Phone: 01772 531378
Email: Peter.McCrone@lancashire.gov.uk
Your ref: 3/2025/0889
Our ref: 3/2025/0889/LCCHET
Date: 26th November 2025

Planning Application: 3/2025/0889. Erection of a part single-storey and part two-storey dwelling of exceptional design quality (NPPF 84e) with associated landscaping, habitat restoration, change of use of land to residential curtilage and access from higher Road, together with the creation of a small visitor car park for members of the public to view the remains of the Roman road to be preserved within the site.(resubmission of application 3/2025/0095) . Land at Higher Road Longridge PR3 2YX

Planning Officer
Historic Environment Team

drawing title Site Plan as Proposed

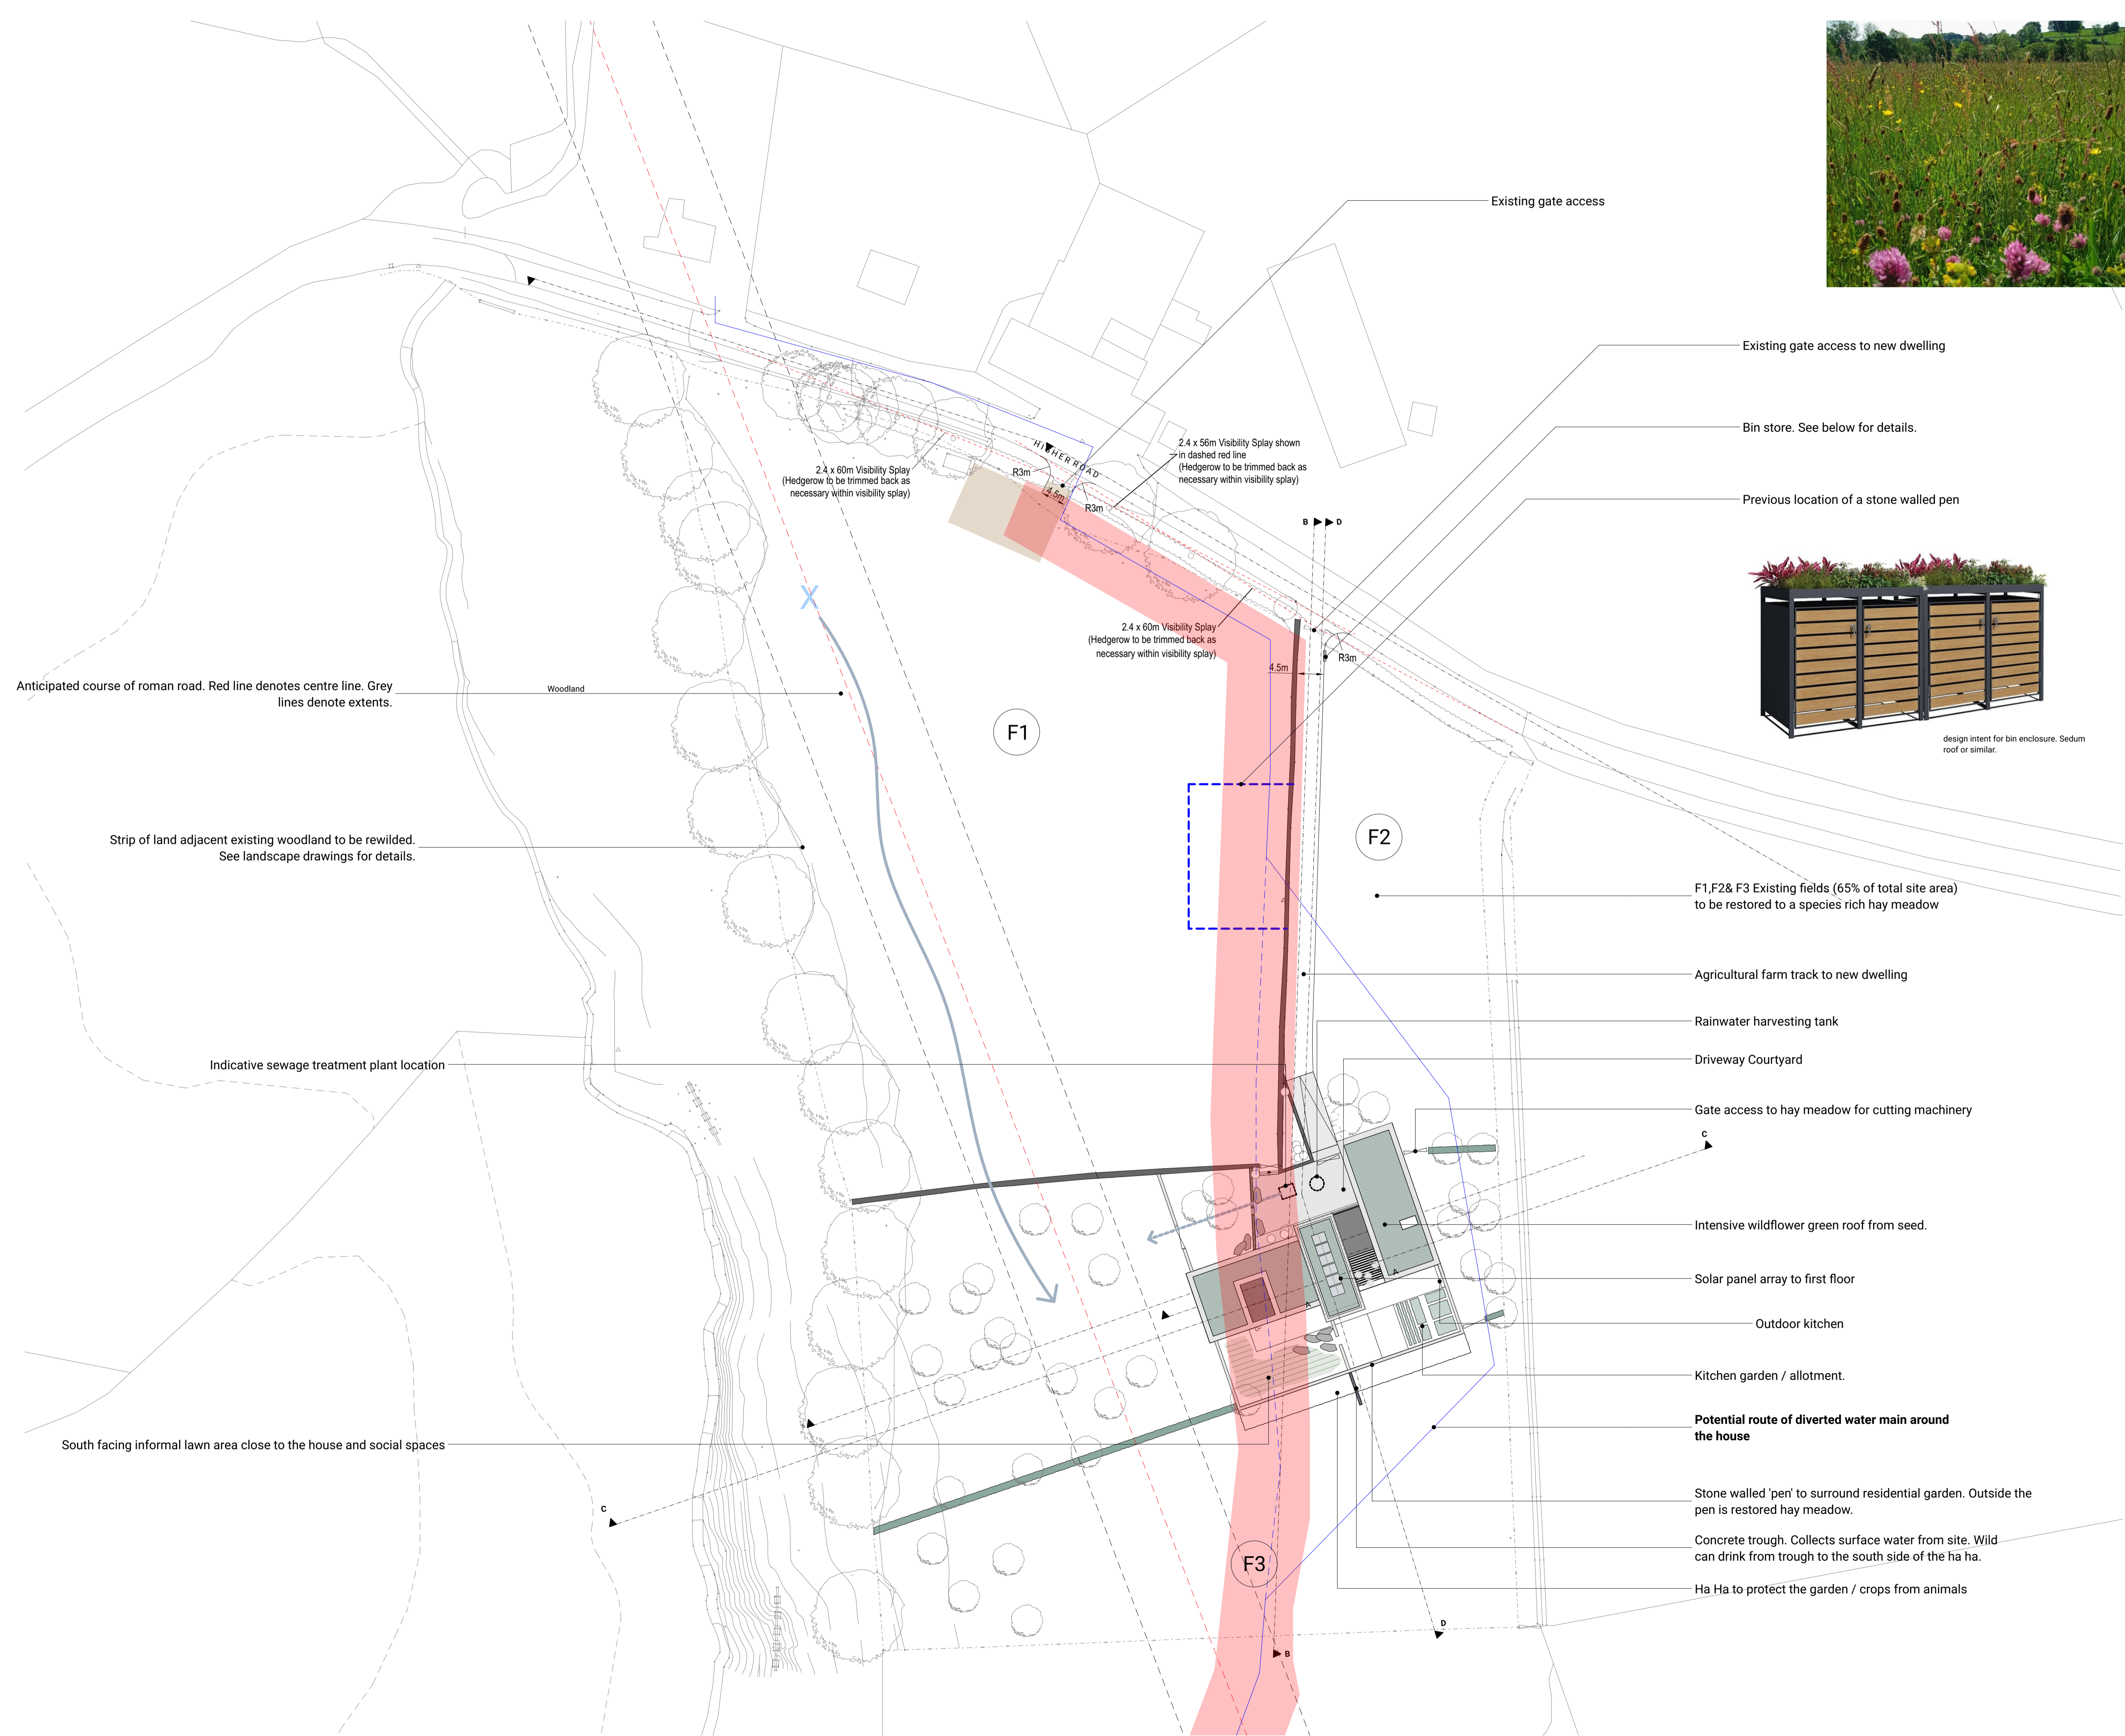
We note the care that has been taken to avoid placing the proposed new dwelling on the line of the Roman road, as well as the possible roadside quarry identified to the west of the road, although we also note that the revised landscape plan includes a ha-ha, a type of ditch with a vertical wall on the "inside" and a sloping face on the "outside" to provide a stockproof barrier between the domestic garden area and the more agricultural and rewilded area of the site. The excavations required for this will inevitably damage the Roman road on the route of the ha-ha. As stated in of the DBA the only known remains that would be impacted by the present plans are post medieval trackways and possible ridge and furrow, although there is still a potential for as-yet unknown buried remains to be affected. There is no indication that any such remains would be of national importance and thus merit preservation at the expense of development, but precautionary archaeological works will still be necessary. We would agree with the DBA (section 5.2) however that these can be required by a planning condition rather than some or all being undertaken prior to determination. We would recommend that these include (i) the erection of a physical barrier on the site to protect the line of the Roman road in the form of well-anchored Herras fencing, chestnut paling or similar, to prohibit access and accidental rutting or damage to the remains of the road; and (ii) a programme of 'strip, map and record' works within (a) the house plot, and (b) any site compounds, bunds, material stores, temporary parking areas, etc., required for the works and (iii) a formal excavation of the section of Roman road affected by the ha-ha. Service runs, including any diversion of existing services, should avoid the fenced-off area of the Roman road, but if this cannot be avoided then these should also be subject to the 'strip, map and record' scheme. The depth of stripping should be sufficient to allow the construction works to proceed or to a depth which shows that no buried remains exist, whichever is the shallower.

Landscape or agricultural works to restore the surrounding hay meadows or 'restore/rewild' the landscape in the immediate vicinity of the Roman road should not include anything that would potentially damage the remains of the road. The planting of trees, shrubs etc. should avoid the identified road corridor and not allow or encourage root spread into or 'scrubbing up' of the road corridor. Any proposed planting of wildflower species should be by seeding or the use of small plant plugs with minimal intrusion into the ground in the area of the Roman road.

Condition: No excavation or ground disturbance works on the application site, including any required for clearance/demolition, site preparation, compounds, services, landscaping, etc. shall take place until the applicant, or their agent or successors in title, has secured the implementation of a programme of archaeological works, to the standards and guidance set out by the Chartered Institute for

- (i) An appropriate method of fencing off and protecting the Roman road corridor; and
- (ii) A programme of 'strip, map and record' across the house plot, any site compounds, bunds, material stores, temporary parking areas, etc., required for the works.
- (iii) A formal excavation of the section of Roman road affected by the ha-ha.
- (iv) Service runs, including any diversion of existing services, should avoid the fenced-off area of the Roman road, but if this cannot be avoided then these should also be subject to the 'strip, map and record' scheme.
